Town & Country Planning (Control of Advertisement) (England) Regulations 2007 (as amended)

1 No. illuminated logo sign with halo lit lettering fixed to wall on front elevation.

Lovelong House 18-22 East Street Littlehampton

Visual at 10% scale

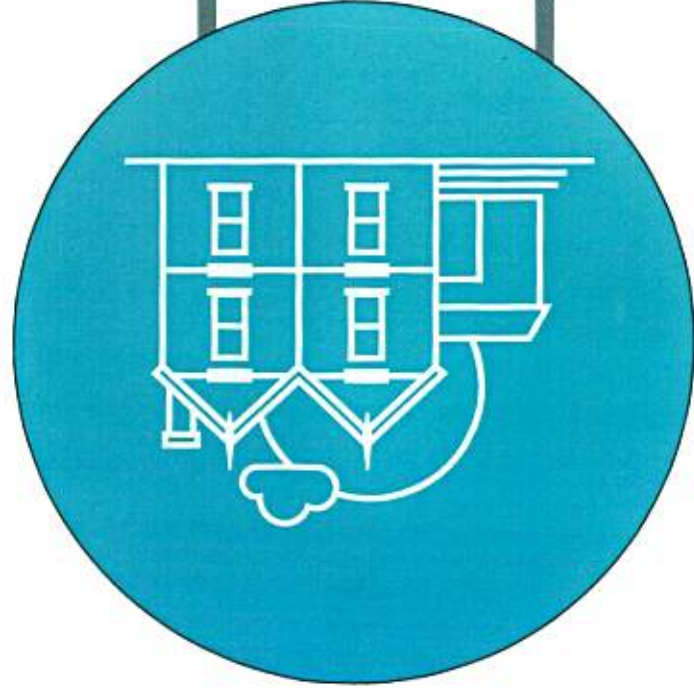
Proposed signage detracts from the appearance of the building and therefore impacts the conservation area. It would be more appropriate etched onto the glass porch.
